PLANNING AMENDMENT

Application No: H18-0388-11 (A1)

Amendment: Revised site layout, Design and Access Statement and
Flood Risk Assessment

**Proposed Building Plots at Rear of 76 New Road, Sutton Bridge
for Mr and Mrs G Ludlow - Planning ref: H18-0388-11**

Drawing Number
11/270/PA/002

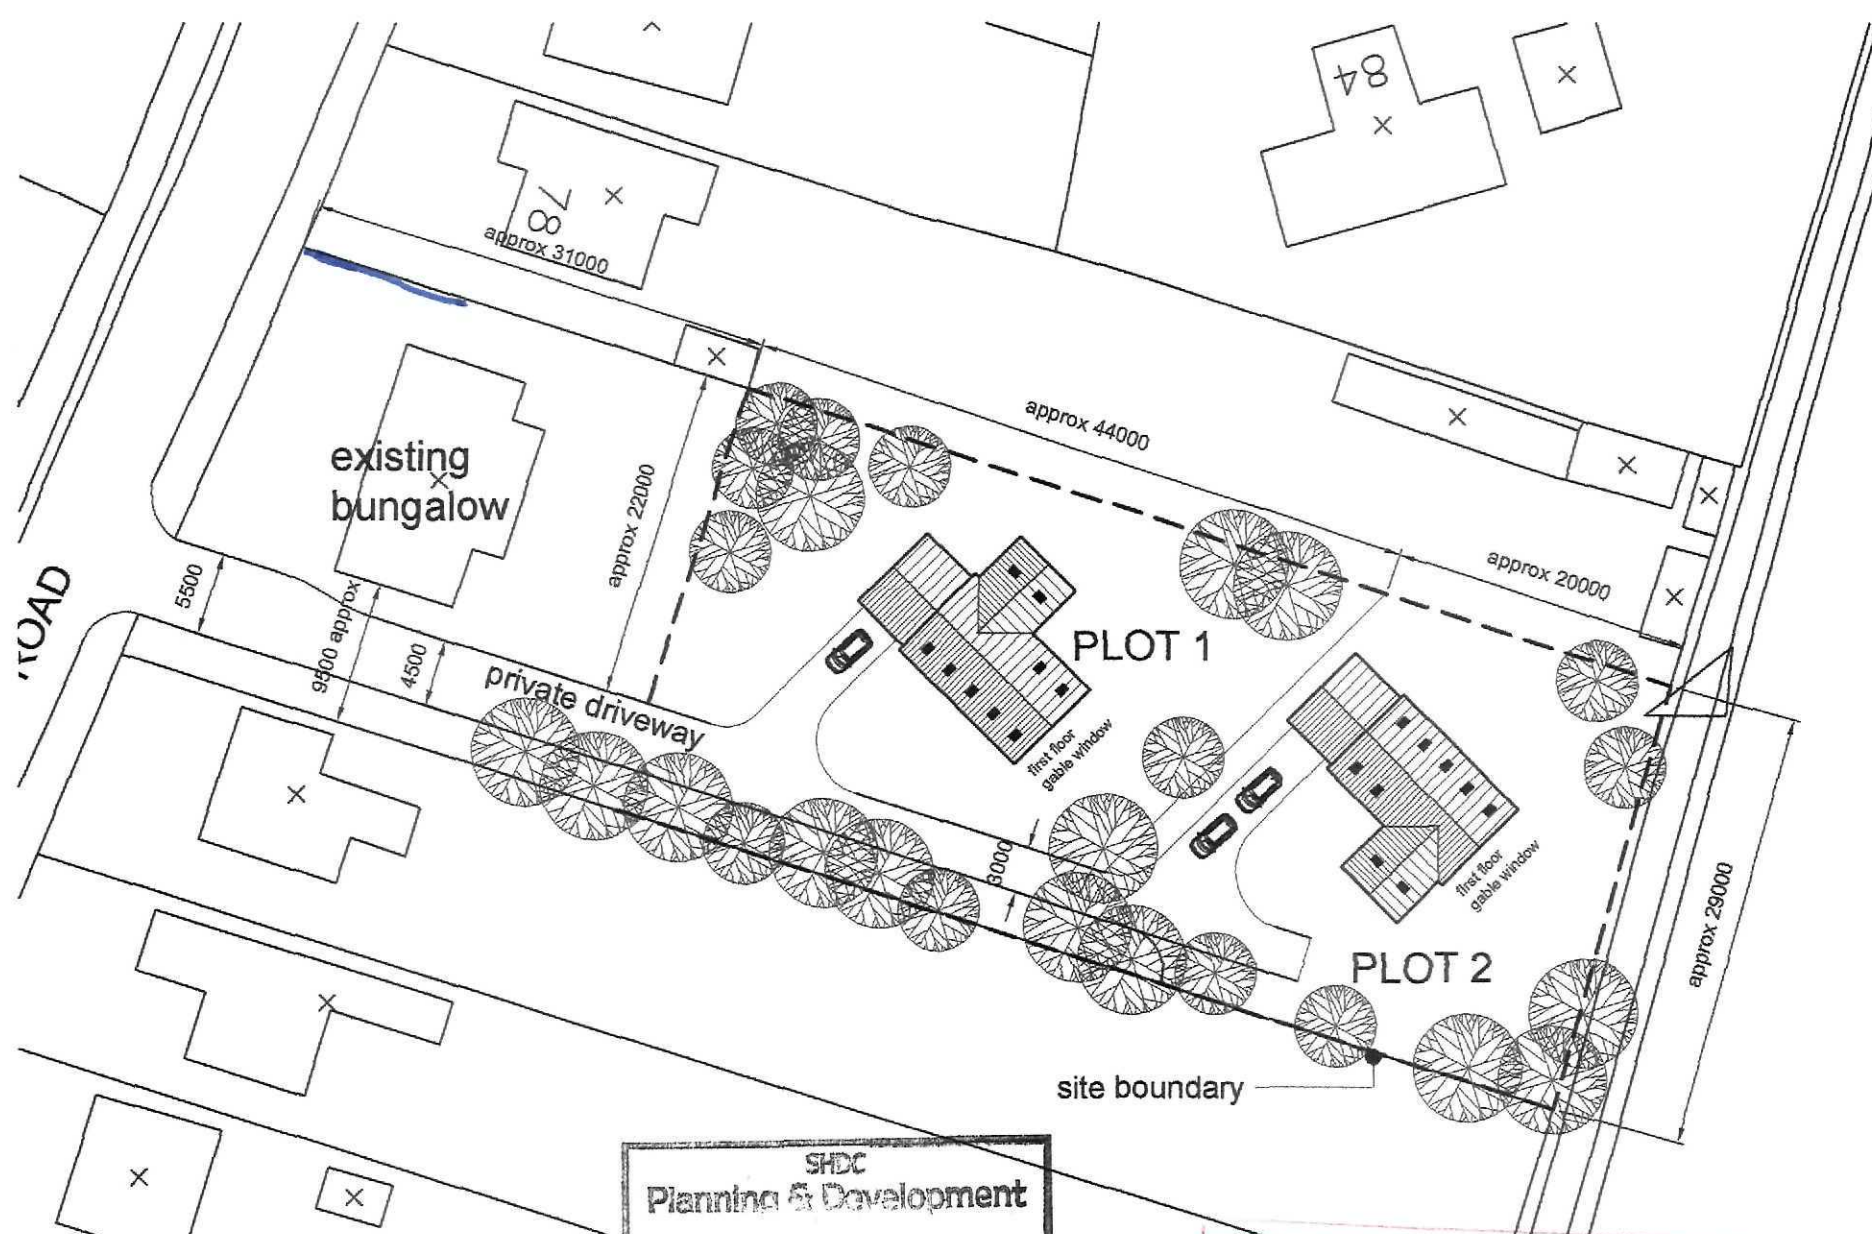
In view of the objection from the EA, a flood risk assessment has been undertaken, two copies of which are enclosed.

I also enclose two copies each of a revised indicative site layout and a D&A statement, both of which respond to the findings of the FRA.

I should be grateful if you would substitute the D&A statement for that previously submitted, and add the revised drawing numbered 11/270.PA/002 to the application documents as an alternative indicative layout please
